REQUEST

Current Zoning: B-1 (Neighborhood Business), B-2 (General Business), I-1(CD) (Light Industrial, Conditional)
Proposed Zoning: MUDD (CD) (Mixed Use Development District, Conditional)

The petition proposes to redevelop the site with a multi-family residential community with up to 350 units and 5,000 sqft of non-residential space.

PLANNING STAFF REVIEW

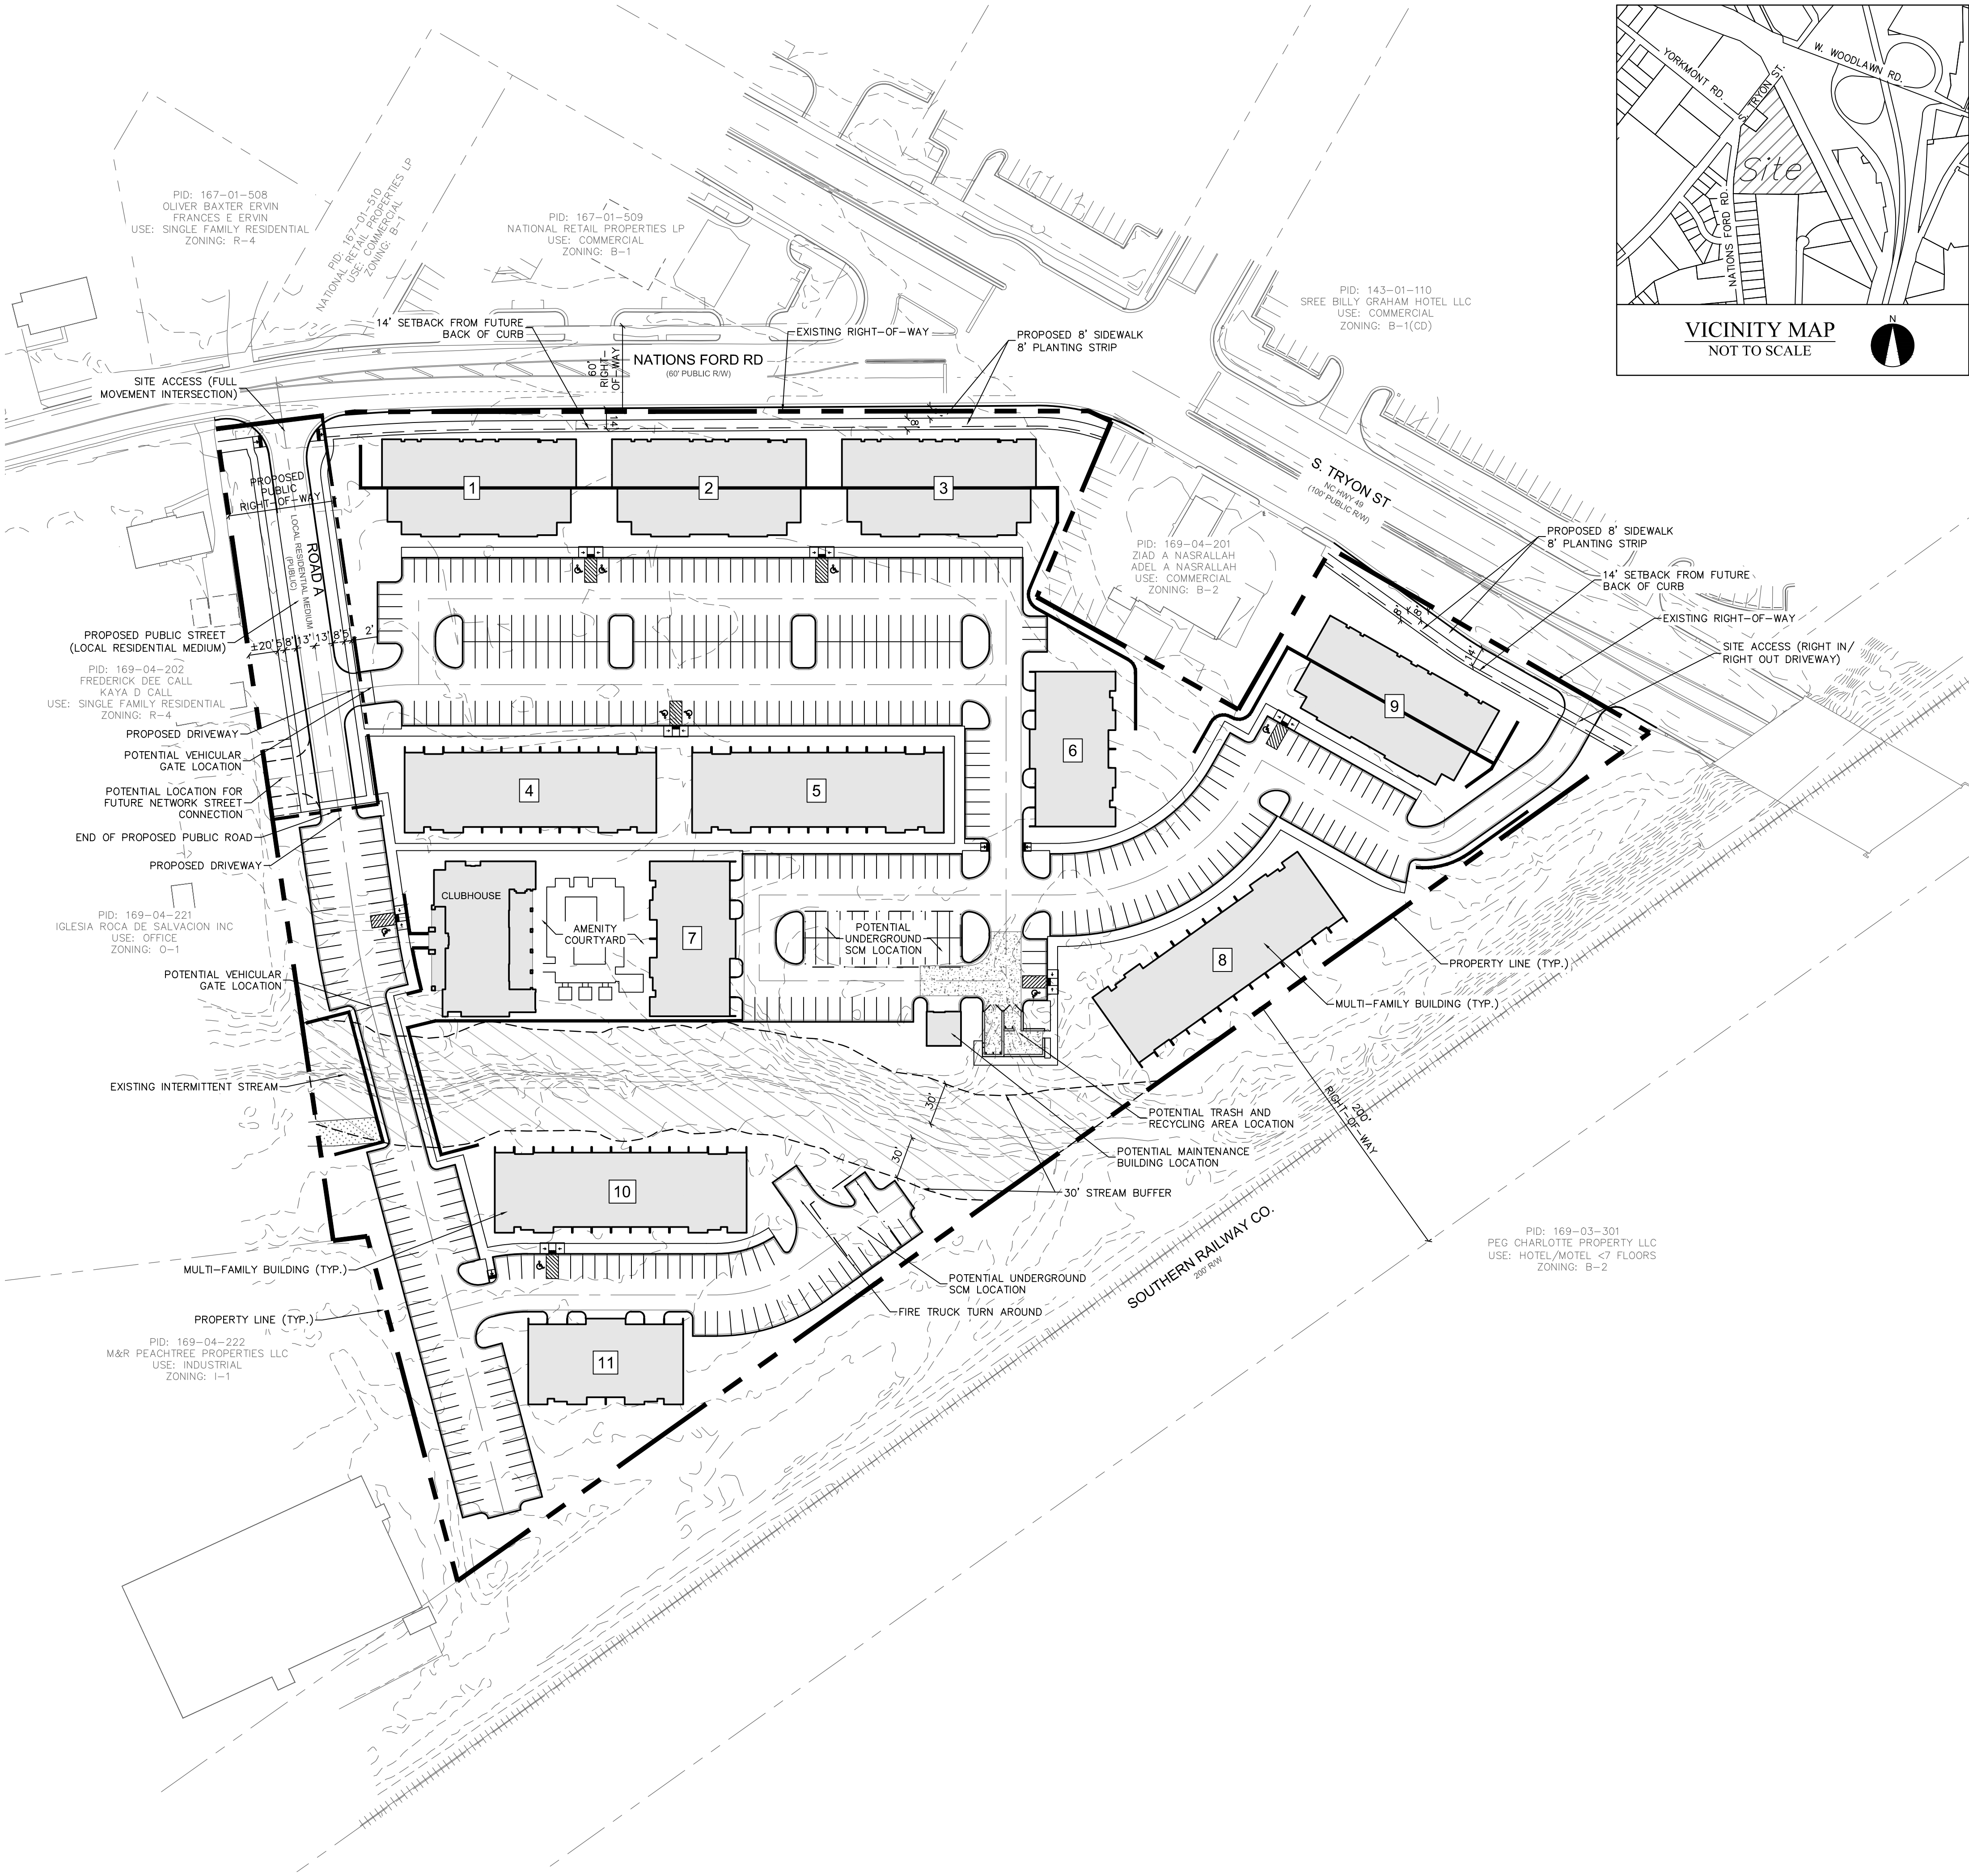
2. Show any existing or proposed pedestrian crossings across Nations Ford Road and South Tryon Street and label accordingly.
3. Amend architectural standards to address treatment of facades facing public streets for example including vertical masonry recesses and prominent columns.
4. Amend architectural note 4.C(1) by removing the option for other materials approved by the planning director.
5. Amend the site plan to provide locations for the sale of goods and services along major streets near interchanges.

6. Provide dimensions for the ROW and back of curb for Road A.
7. Shift bike ramp to precede the pedestrian crossing, extend the MUP to new ramp location.
8. CDOT requests the petitioner provide a signalized ped crossing at Nations Ford Rd. at the existing traffic signal to aide safe pedestrian circulation at the intersection which does not currently have any pedestrian accommodations. There is a City CIP project installing 2 additional crossings at this location but because no sidewalk existed at the development site the project did not provide a crossing.
9. Install ramps, crosswalk, and pedestrian signals to cross Nations Ford Road. CDOT CIP project is planning on installing cold joints in the pork chop island for a 12' ramp to cross Nations Ford. Due to the curb line moving to accommodate the buffered bike lane, the CIP project cannot install the ramps.
